Application No: FG/32/25/HH
Site Address: 1 Greenways Crescent Ferring BN12 5EF
Description of works: Erection of 1.8m high close boarded timber fencing along the eastern boundary.

Thank you for your internet representation made on 4th April 2025 which has been recorded as an objection with the comments as follows:

DRAWING TITLE
Existing Site Plan

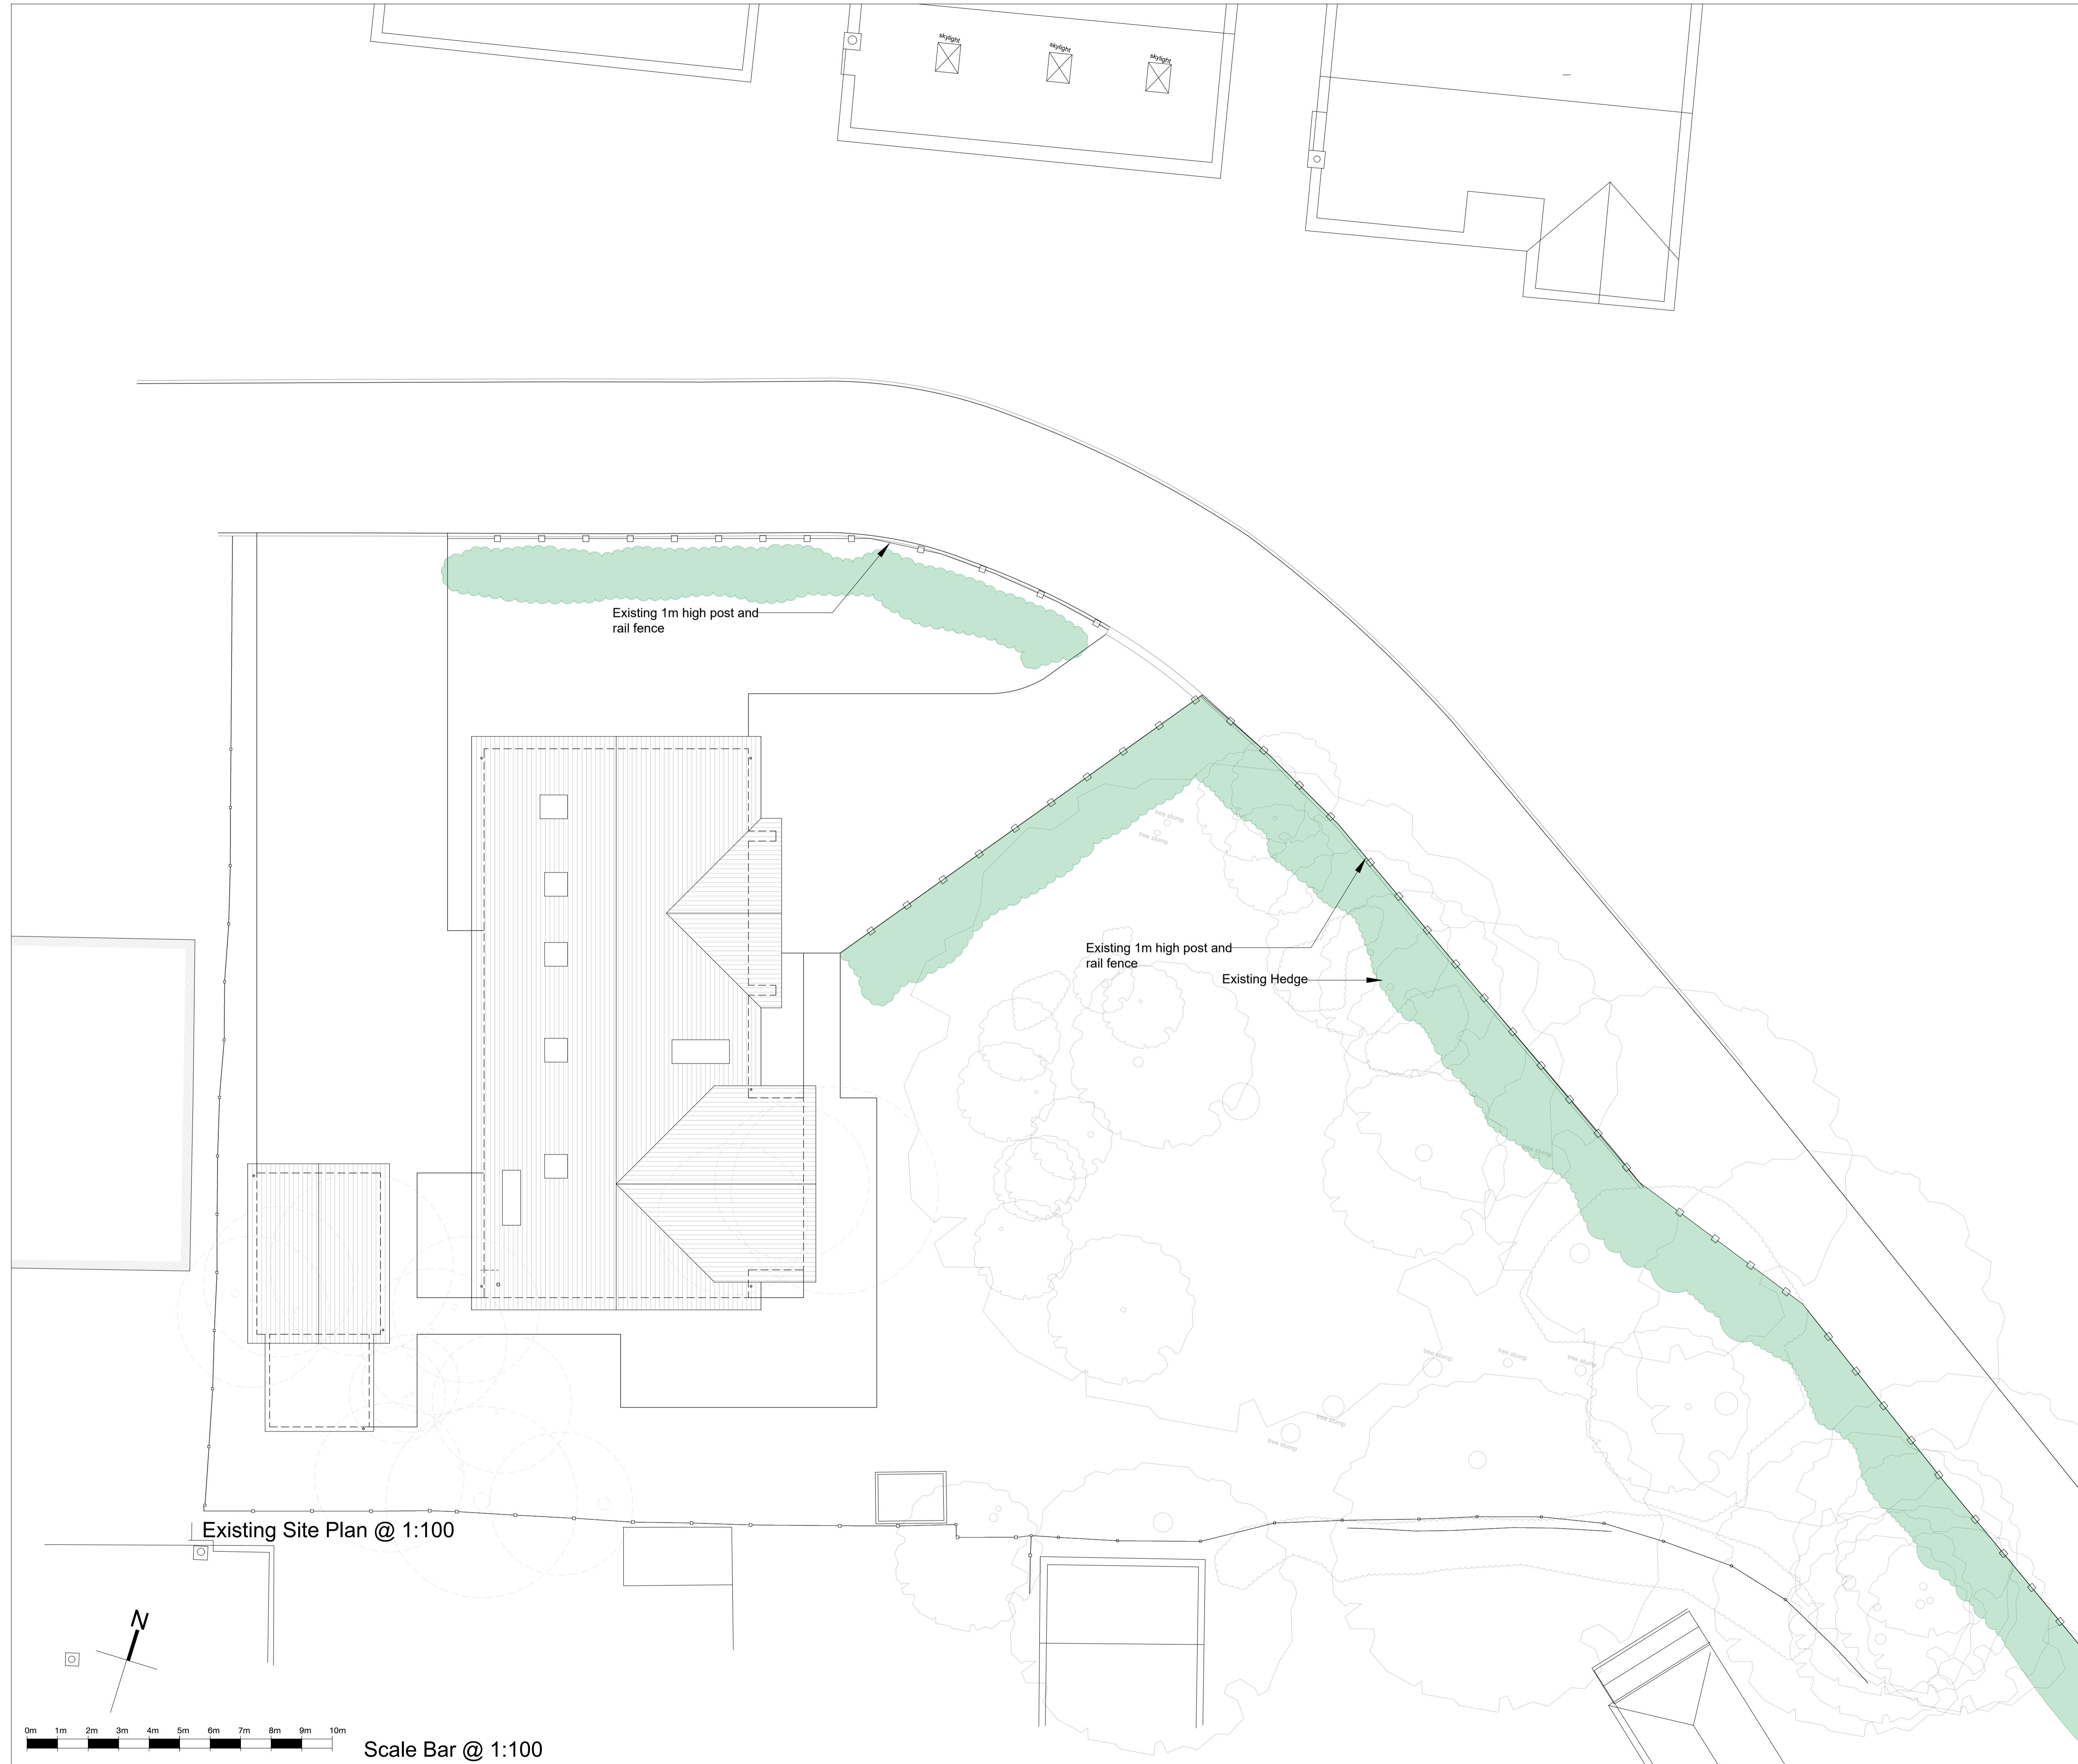
Has there been a mistake with this application? In the application there is a signed declaration saying that the land to which the application relates to is wholly owned by the owners of no1. This land is defined by the red line. The drawings show the fence line comes out to the kerb beyond the existing fence and bushes even takes in the muddy bit where there is no made road. This would be very imposing on the road and houses opposite this current proposal.
